**From:** [Cameron Curtis](#)  
**To:** [Arden Thomas](#); [Kelly Bacon \(CD\)](#)  
**Cc:** [Gail Weyand](#); [Candie Leader](#); [Josh Fredrickson](#); [Justin Turnbull](#)  
**Subject:** RE: VA-20-00013 Pratt - Additional Information  
**Date:** Thursday, April 1, 2021 12:54:29 PM

**From:** Kelly Bacon (CD) <[kelly.bacon.cd@co.kittitas.wa.us](mailto:kelly.bacon.cd@co.kittitas.wa.us)>  
**Sent:** Monday, March 22, 2021 4:24 PM  
**To:** Candie Leader <[candie.leader@co.kittitas.wa.us](mailto:candie.leader@co.kittitas.wa.us)>  
**Cc:** Gail Weyand <[gail.weyand.pw@co.kittitas.wa.us](mailto:gail.weyand.pw@co.kittitas.wa.us)>  
**Subject:** VA-20-00013 Pratt - Additional Information

I have obtained an updated site map showing the required setbacks from the Type 1 Stream located on the Pratt Property. PW comment C requested the updated site map showing the shoreline setbacks. I am unsure who's comment this was, so I thought I would start with you.

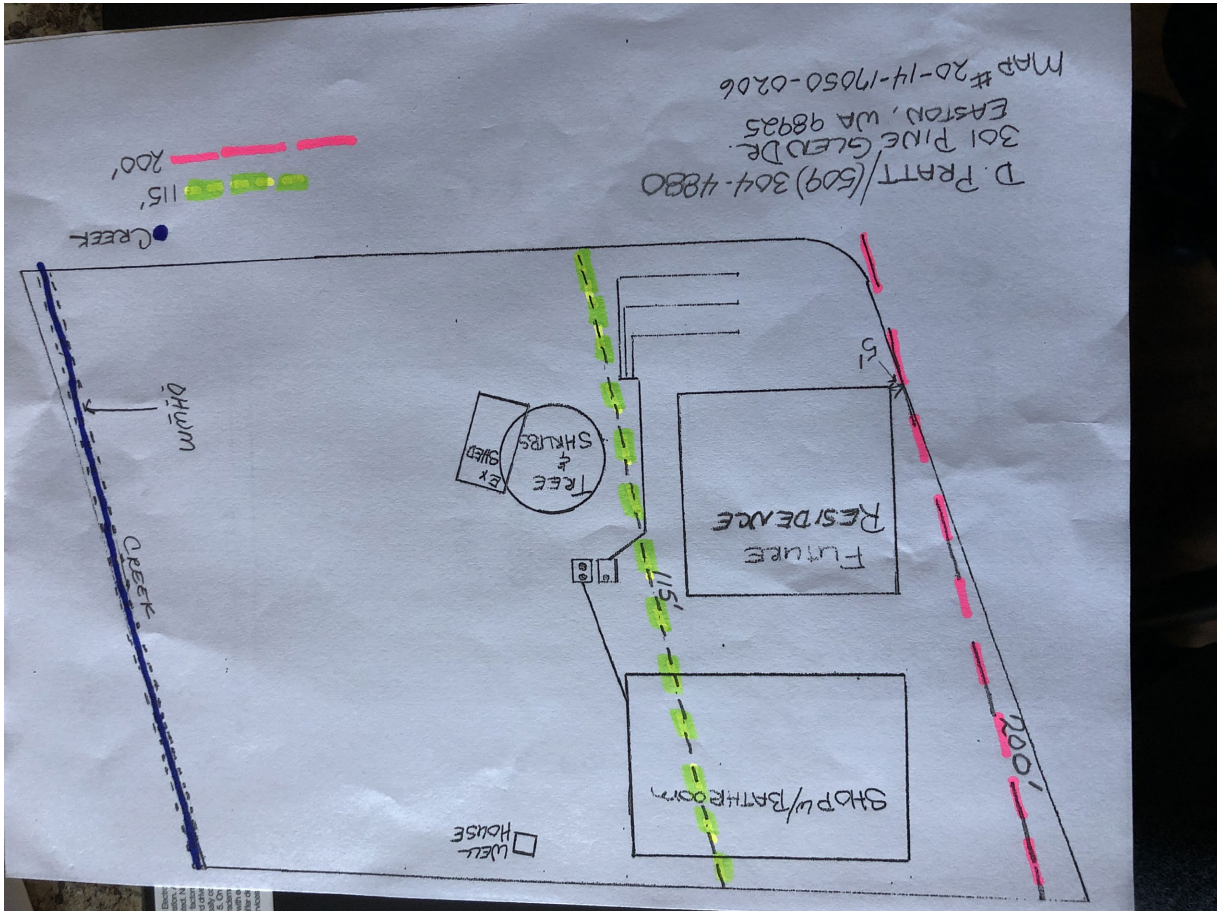
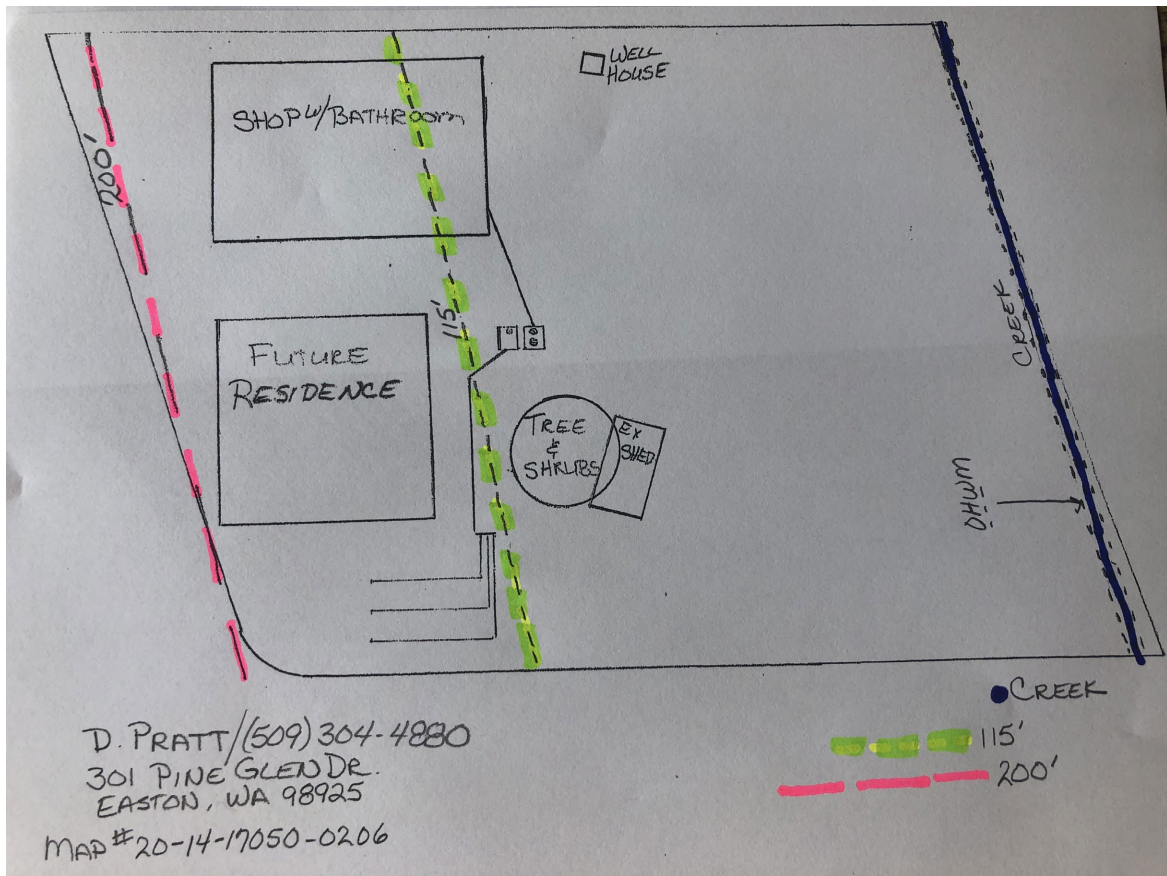
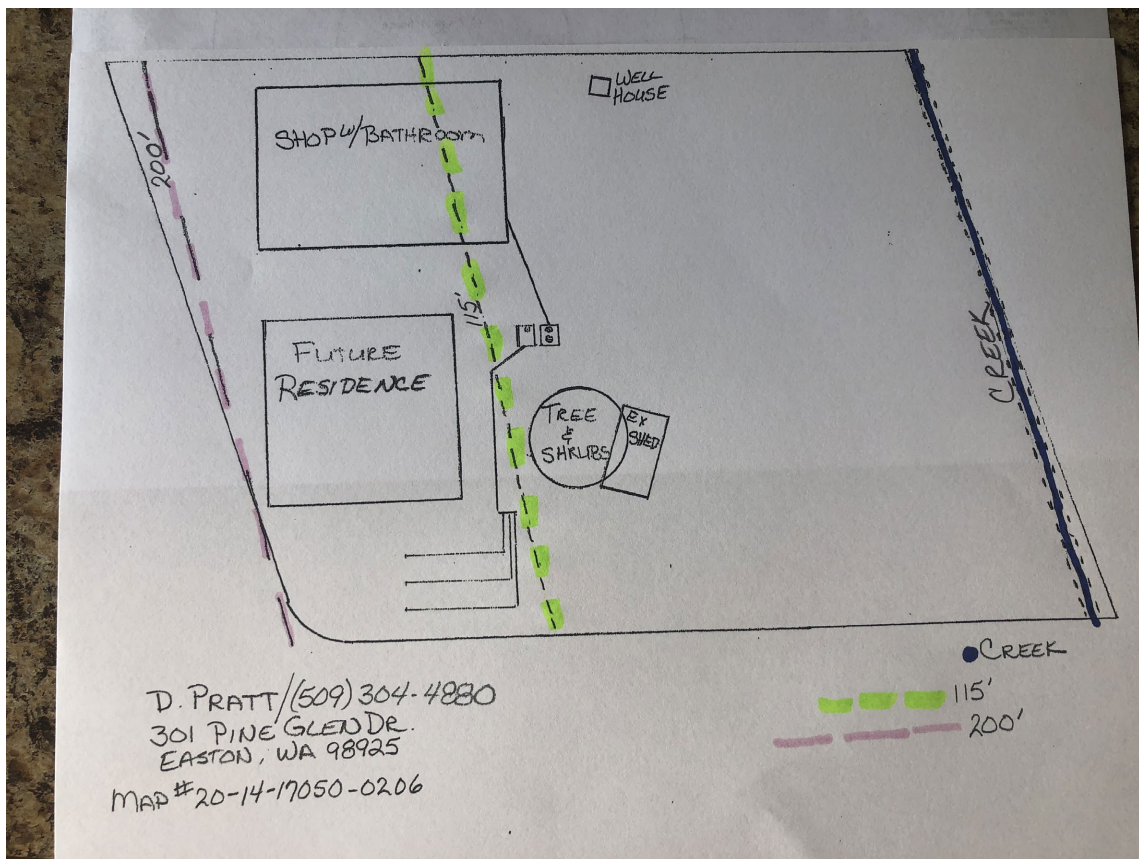
1. Based on the updated site plan, it appears that the structure could be moved so that the corner of the residence is more than 1-ft from the property corner. Public Works is not supportive of a variance to allow 1-ft setback. Public Works' concern is related to future conditions where a 1-ft set back may become an issue. Cameron Curtis and Josh Fredrickson are both happy to meet with the applicant to talk through potential issues. In this situation Public Works would be comfortable with a minimum 5-ft setback, but the applicant should make every effort to increase this set back distance as much as possible.

Cameron Curtis provided comment C, so I am looping Cameron and Josh into this e-mail. The concern identified in comment C is that a 1 foot setback against the property line is not sufficient given potential conflict with future development of the private road intersection. Based on the information provided in the original application, PW opposed a variance which allowed a building to be placed within a foot of the property line. Josh or Cameron will need to review the additional information provided by the applicant (I've attached the updated site plan and the applicant's response to comments) to determine if their concerns have been addressed.
